**Yorkshire Water Services
Developer Services
Pre-Development Team
PO BOX 52
Bradford
BD3 7AY**

Our Ref: Y003167

18th March 2022

Land north of Shaw Lane, Carlton, Barnsley - Residential development of up to 215 dwellings with associated car parking/garages, landscaping, public open space including both equipped and non-equipped areas of play, SUDS and drainage, with details of a new vehicular access onto Shaw Lane (Outline with all matters reserved apart from means of access)

**Figure 9 – Pond Outfall**

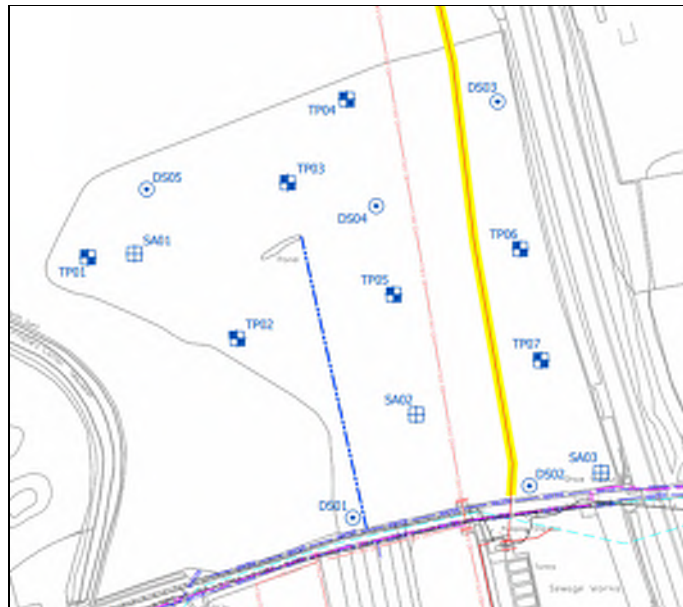
As the proposal site is currently undeveloped, no positive surface water is known to have previously discharged to the public sewer network. As a last resort, we will accept a surface water connection to the 1200 mm diameter public surface water sewer to the south of the site, at a maximum rate of 3.5 (three point five) litres per second.

Public Waste Water Network 12/03/2019 16:10:06 OS Grid Coordinates: 436904 : 409937 Map Name : SE3009NE

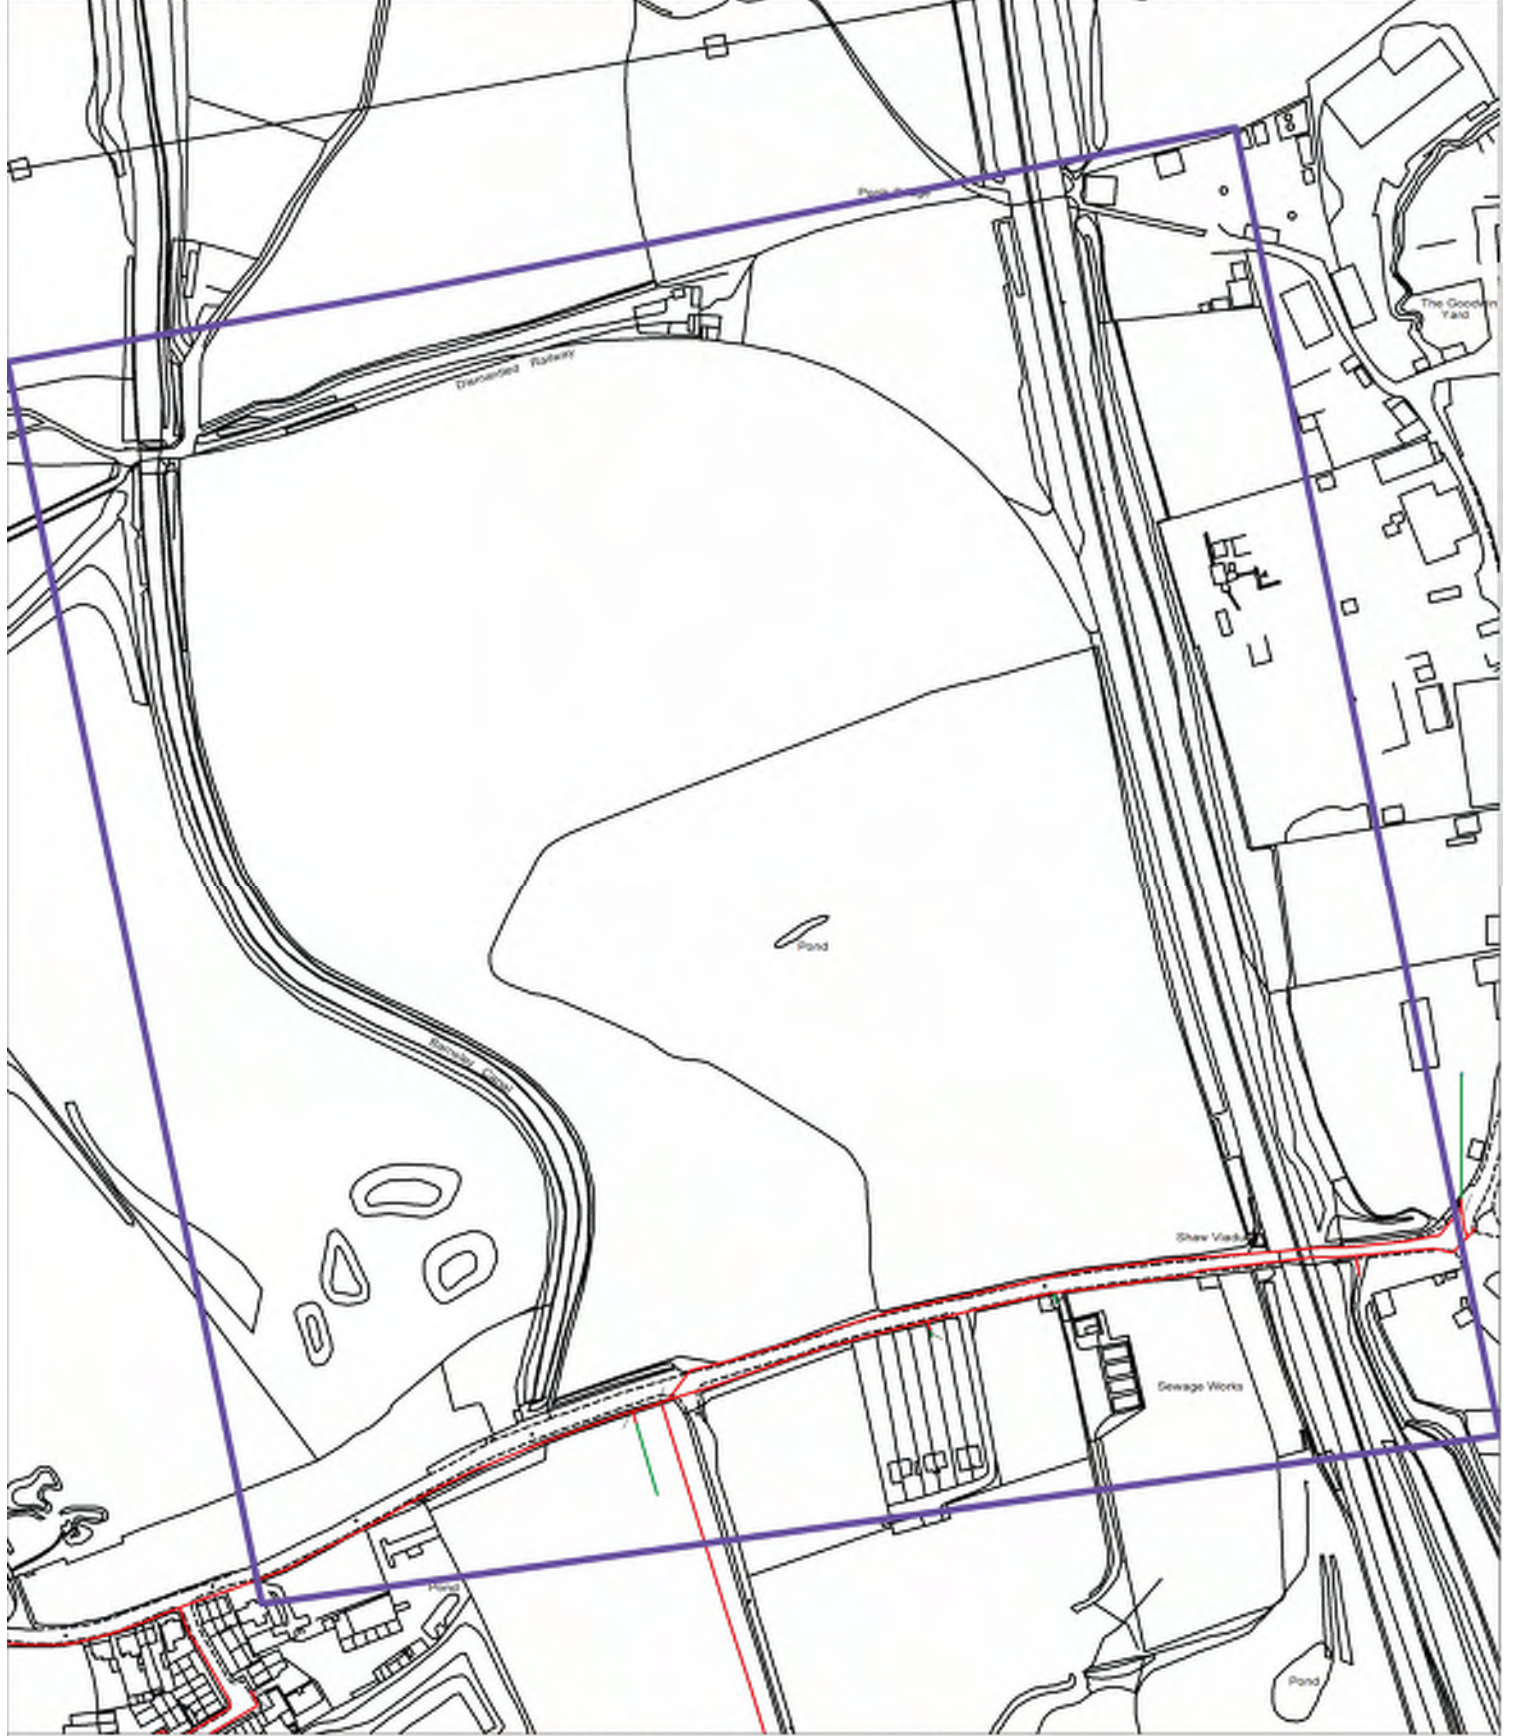
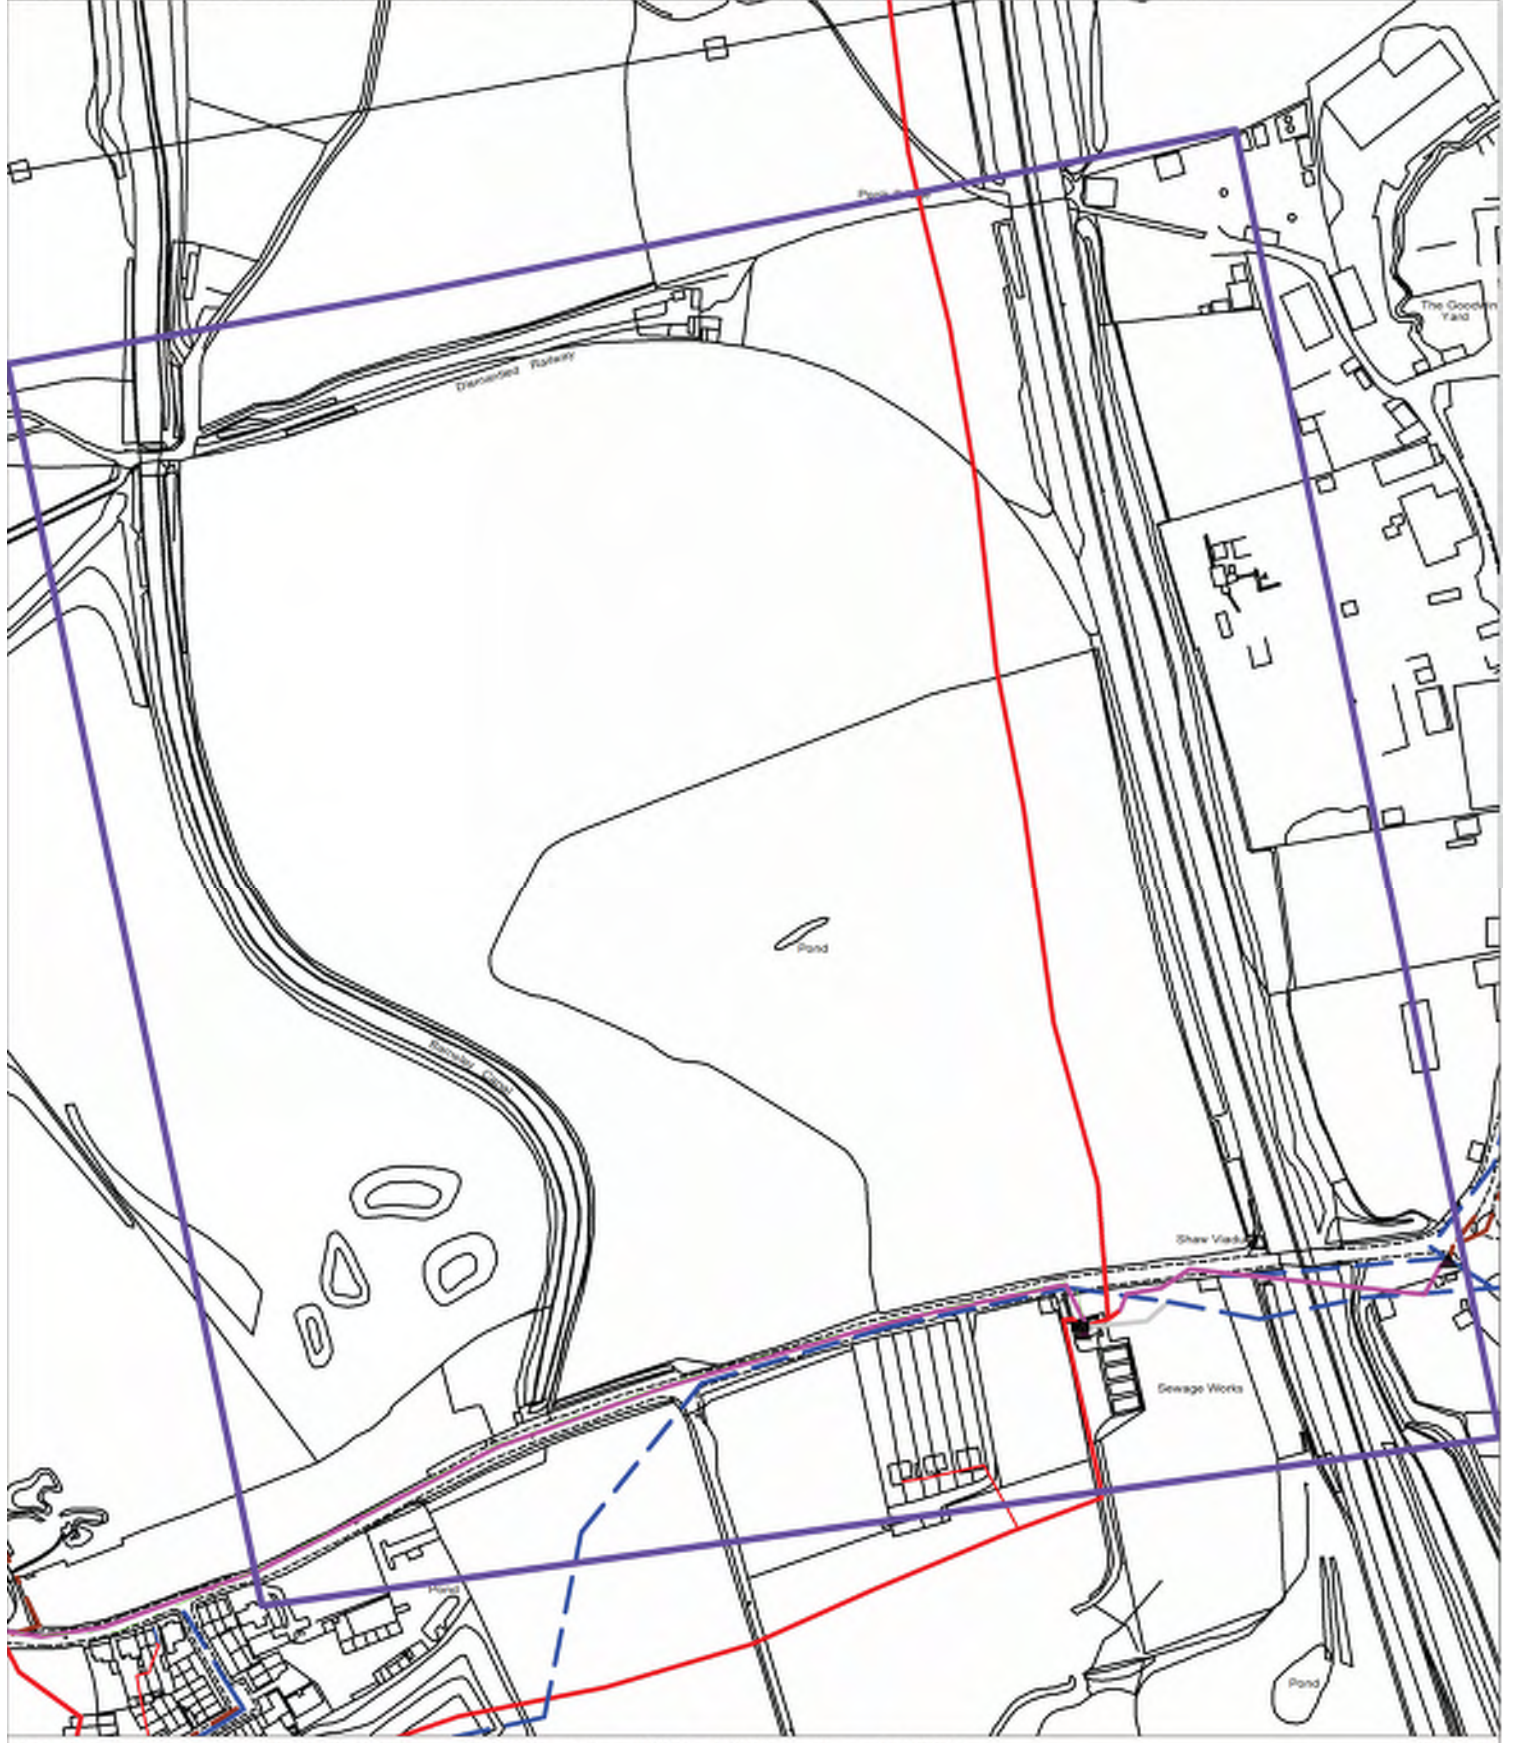
3) On the Statutory Sewer Map, there is a 525 mm diameter public combined sewer recorded to cross the site. It is essential that the presence of this infrastructure is taken into account in the design of the scheme. It may not be acceptable to raise or lower ground levels over the sewer and we will not accept any inspection chambers on the sewer to be built over.

In this instance, a stand-off distance of 5 (five) metres is required at each side of the sewer centre-line and it may not be acceptable to raise or lower ground levels over the sewer, nor to restrict access to the manholes on the sewer.

It would appear that the public sewer is unlikely to be affected by building proposals; however, prior to the submission of reserved matters, we strongly recommend that the sewer is surveyed and that no buildings or other landscaping features including trees are within the specified stand-off distance.

No building or other obstruction including landscape features shall be located over or within 5 (five) metres either side of the centre line of the public sewer i.e. a protected strip width of 10 (ten) metres, that crosses the site. If the required stand-off distance is to be achieved via diversion or closure of the sewer, the developer shall submit evidence to the Local Planning Authority that the diversion or closure has been agreed with the relevant statutory undertaker and that prior to construction in the affected area, the approved works have been undertaken.
